Recommendation Report for Planning Permission

REF NO:	AB/48/19/PL
LOCATION:	Sparks Yard 18 Tarrant Street Arundel BN18 9DJ
PROPOSAL:	Change of uses to form an upper floors single, four bedroomed residential unit (use class C3a) & a ground floor commercial unit (use classes A1, A2 and B1a), together with all associated works. This application affects the character & appearance of the Arundel Conservation Area.

A6001-05A

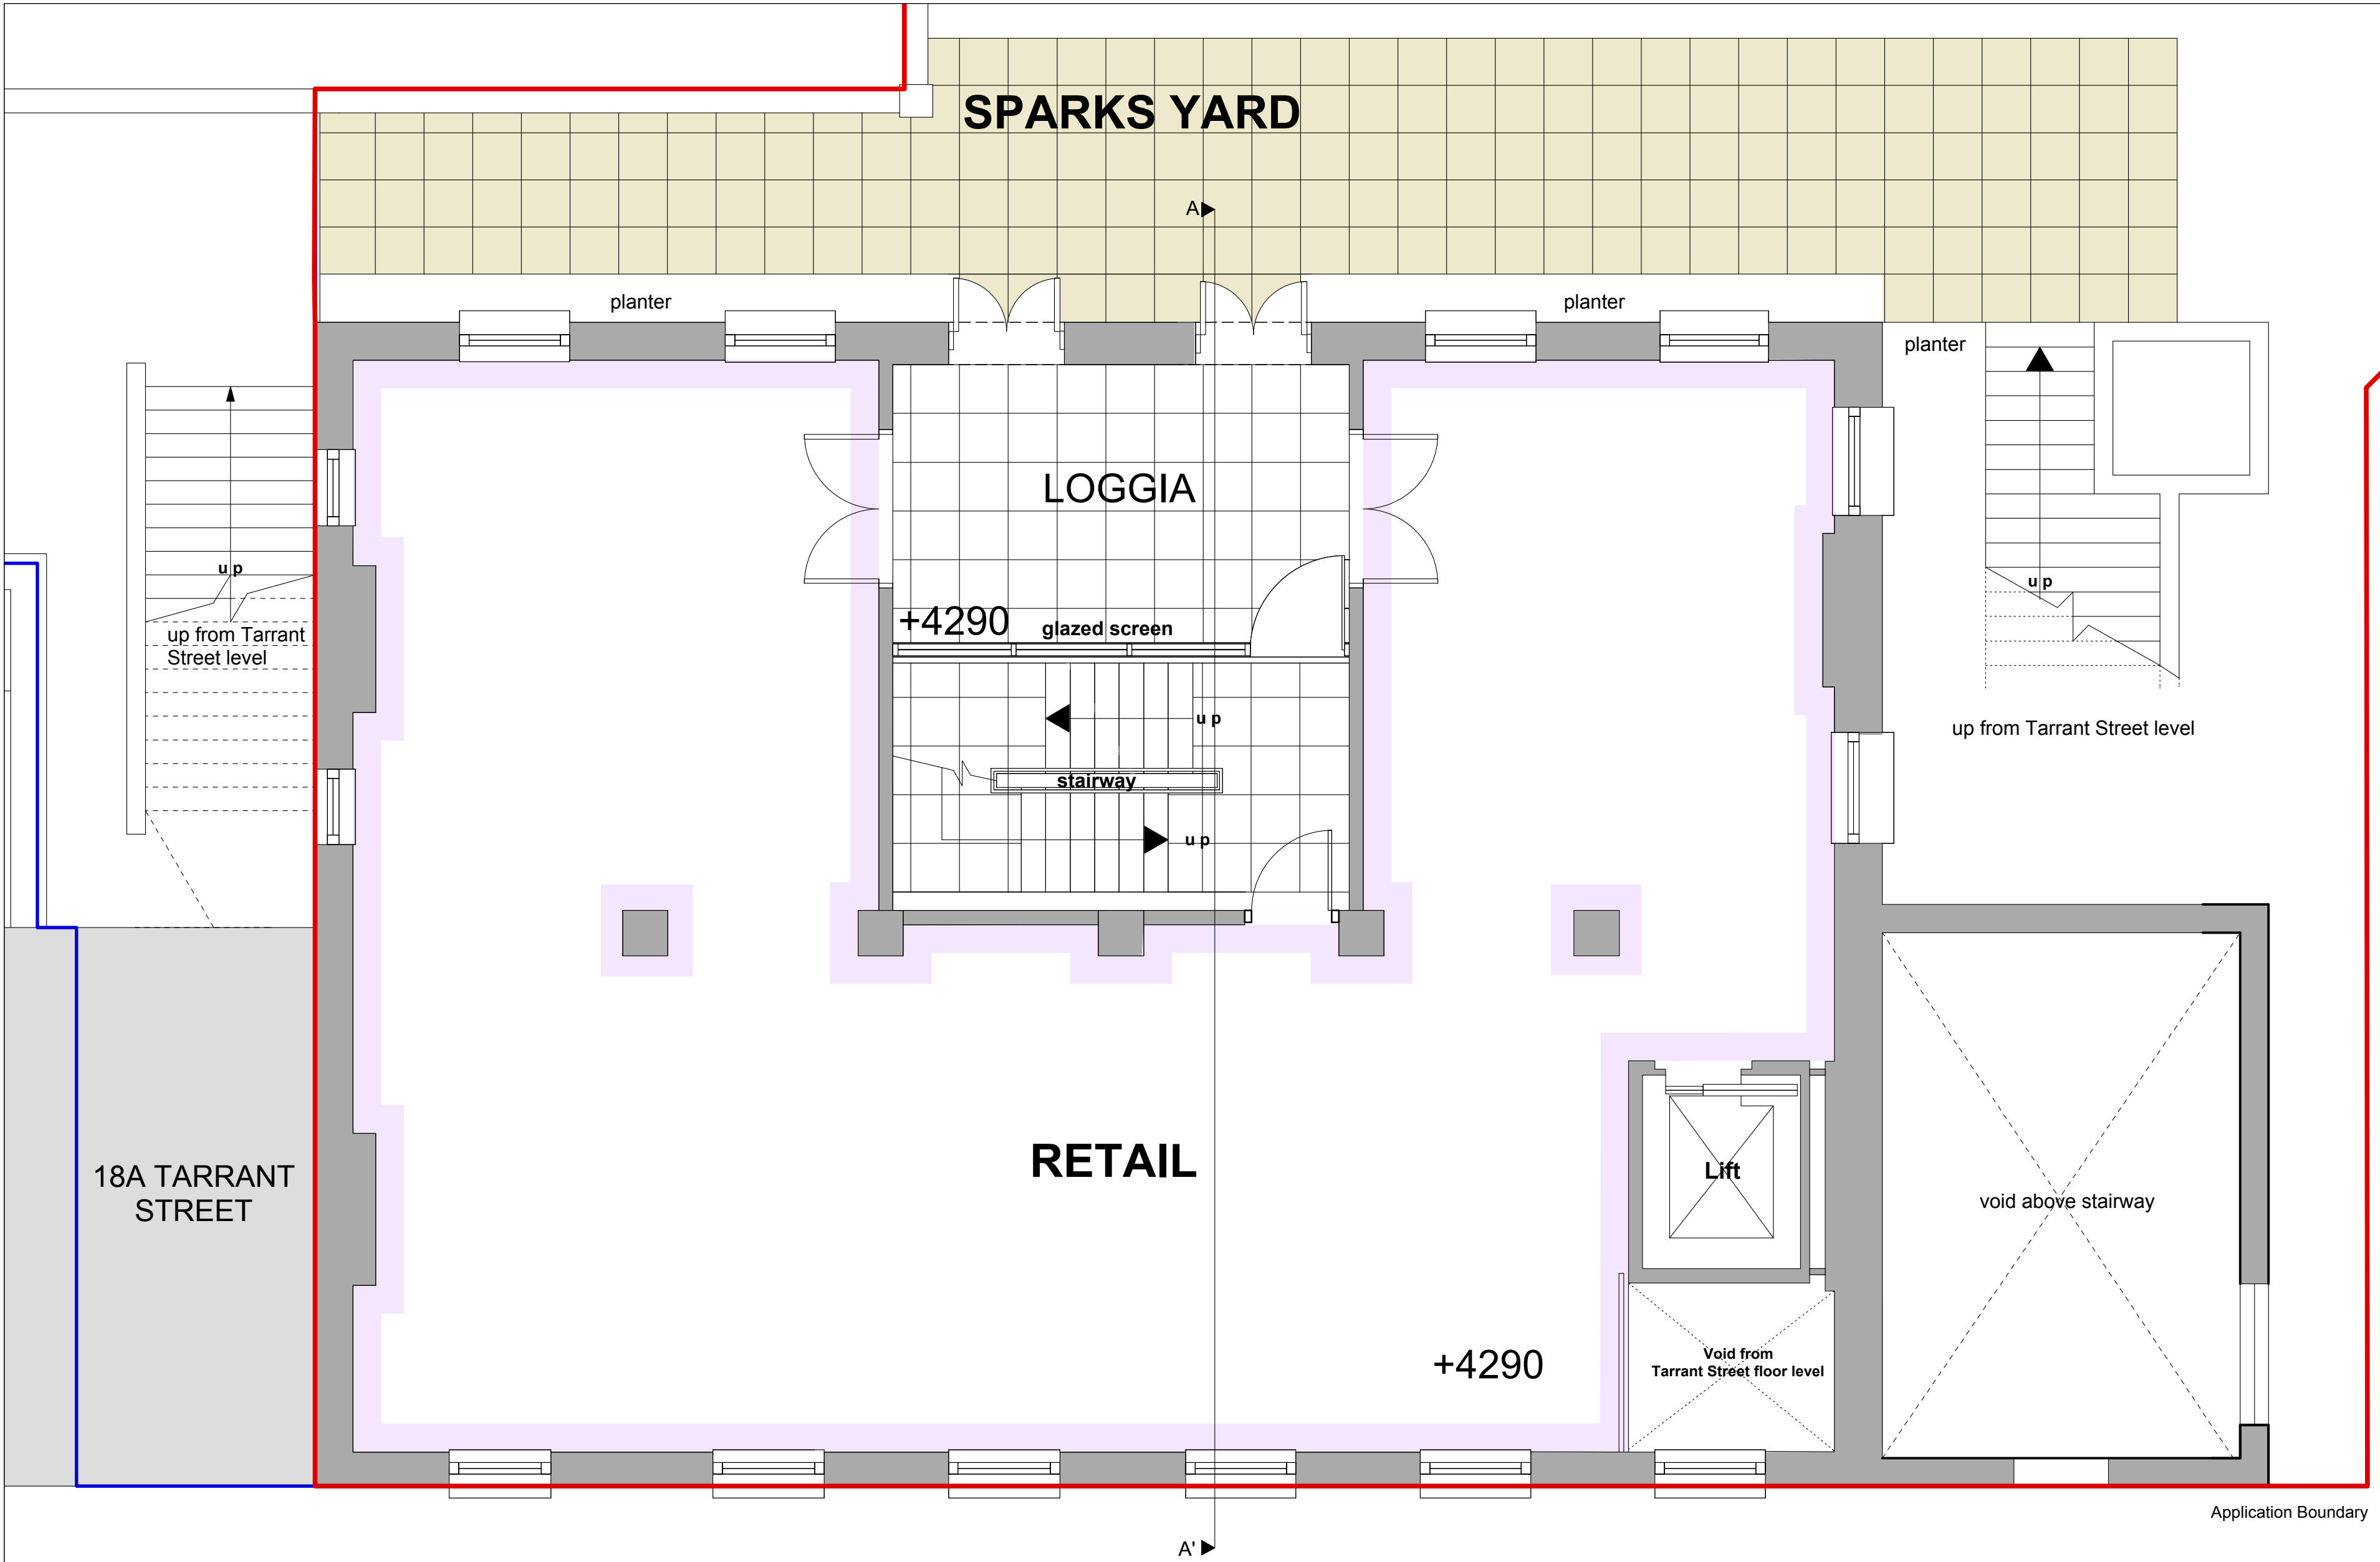
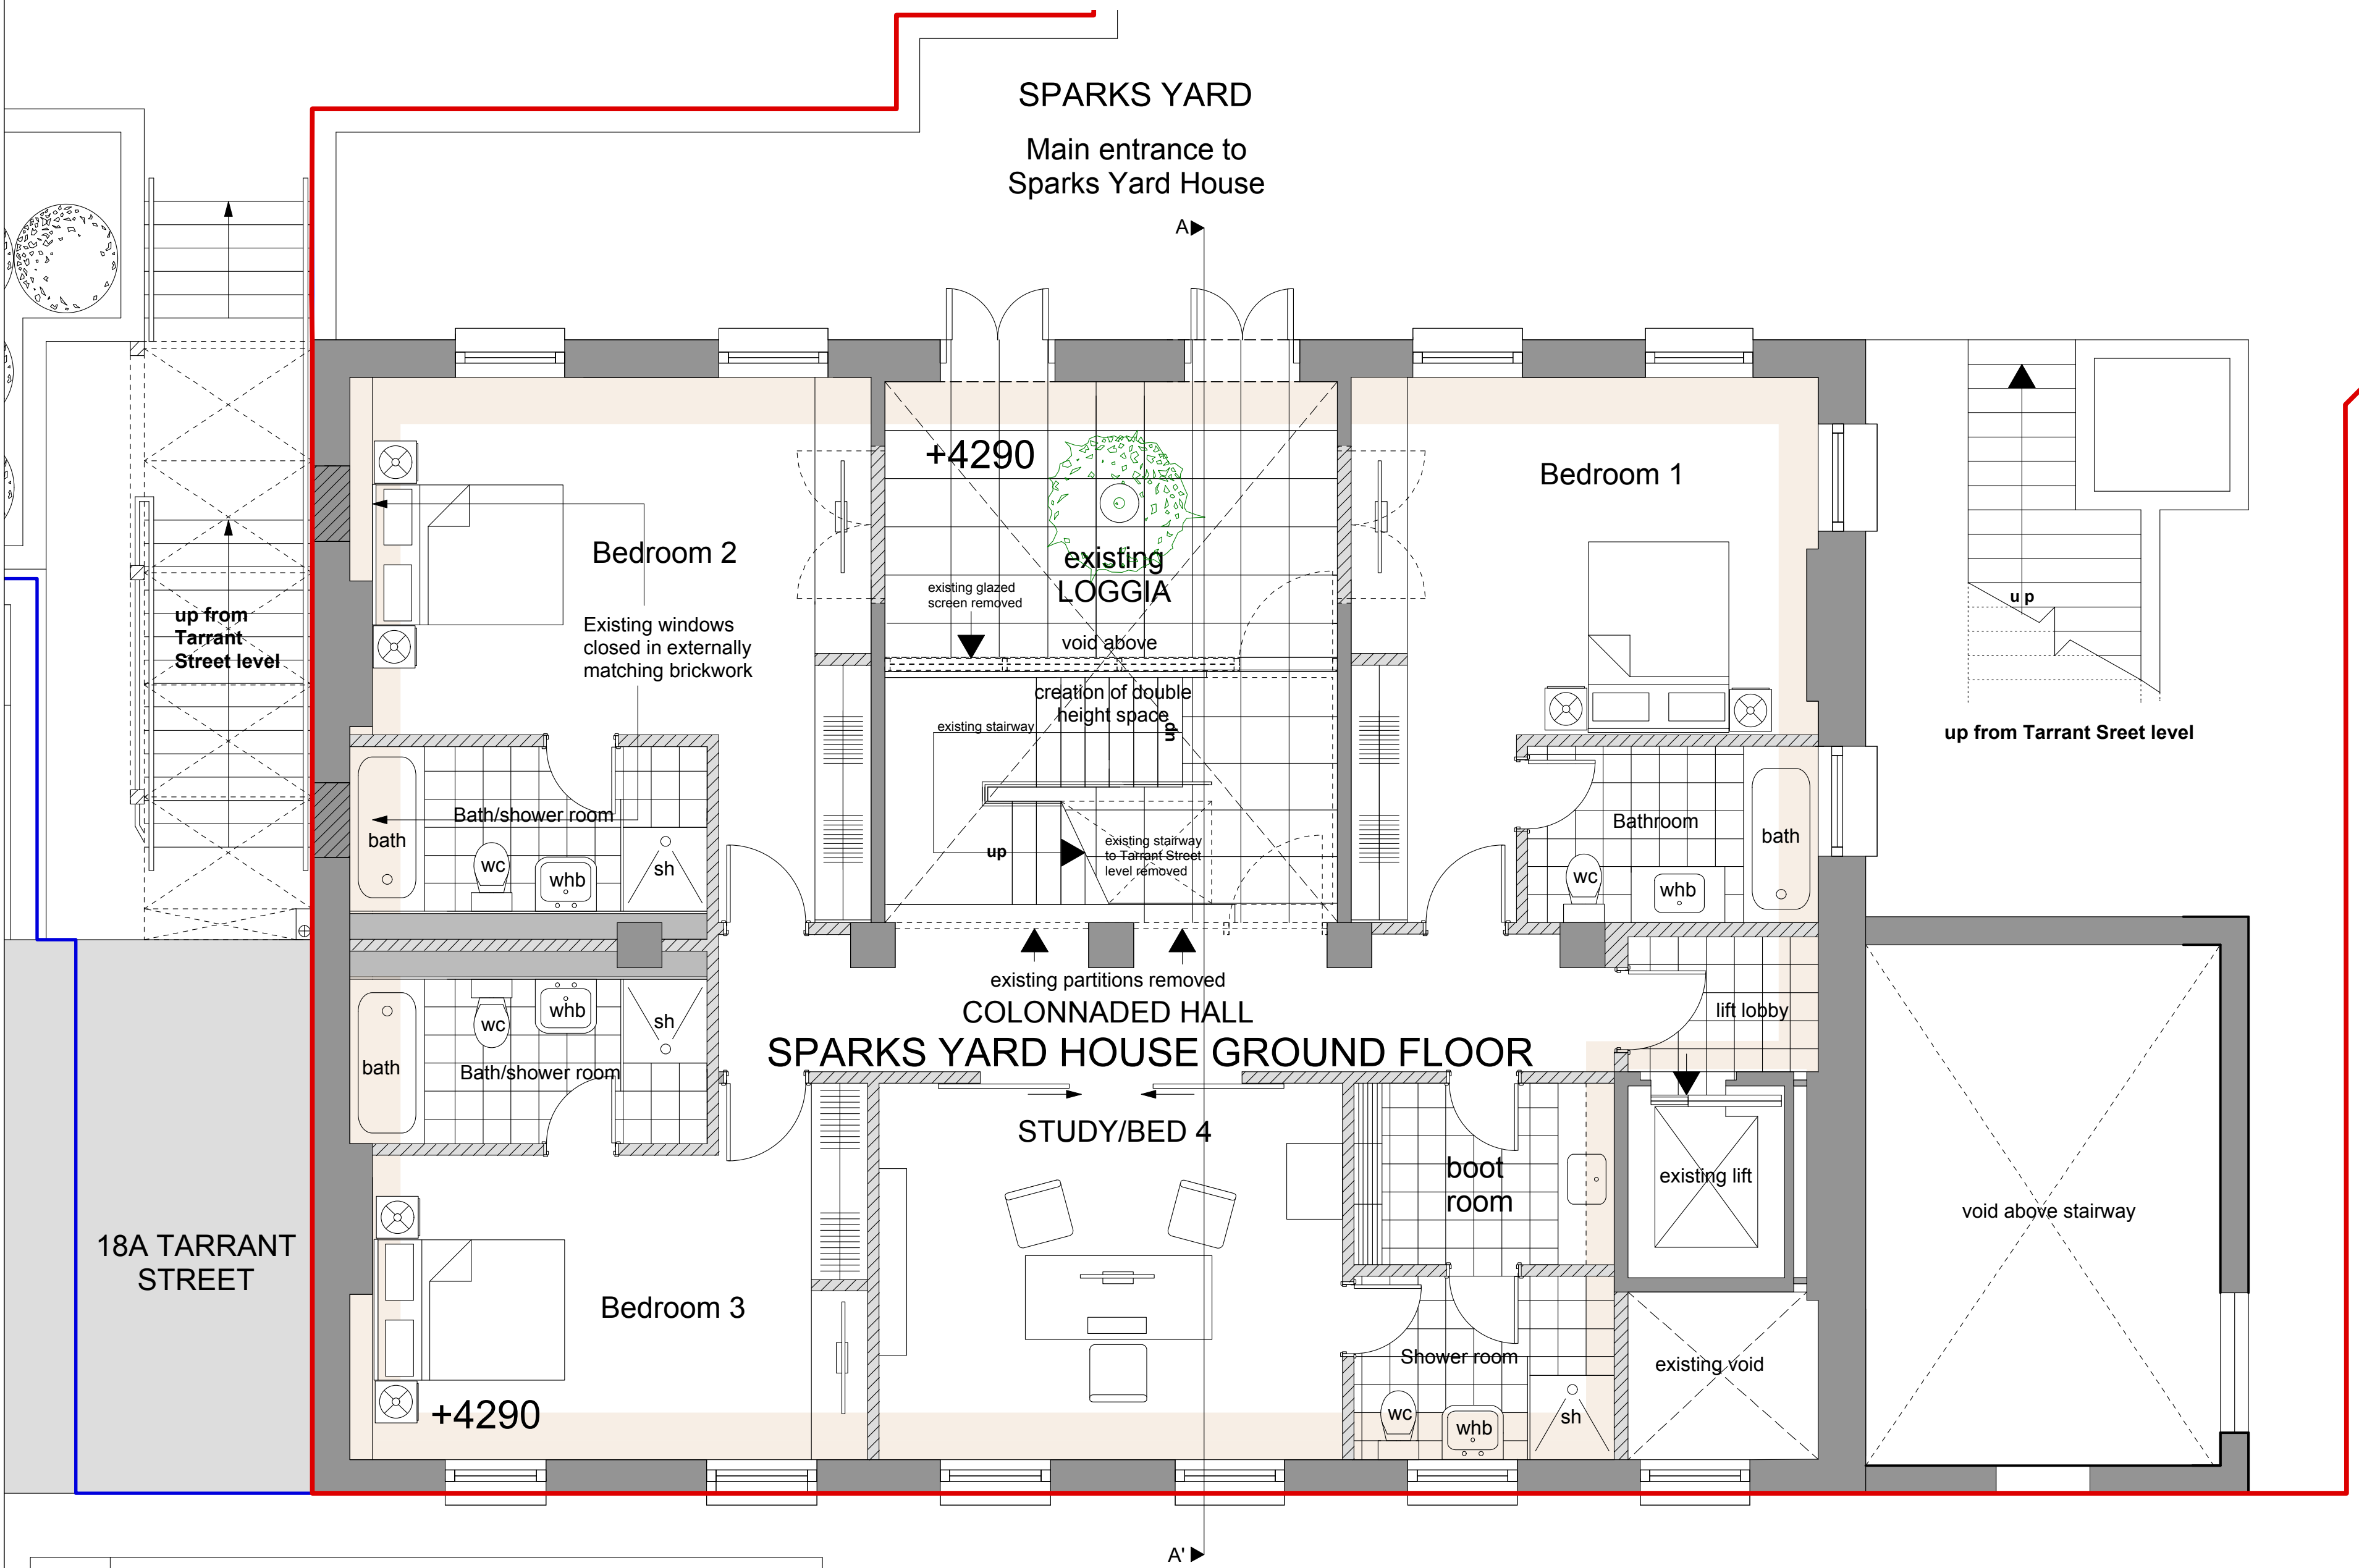
- The alterations to the middle floor allow for modern day living, whilst creating a spacious layout.
- Covering internal brick walling with plasterboard should be reconsidered.
- More information should be submitted relating to the works to the curtilage wall.
- The removal of all damaging drainage pipework from the western elevation will have a positive impact upon the appearance of the building.

The plasterboard faced, insulated internal wall linings to the upper two floors of the building have been removed from the application.
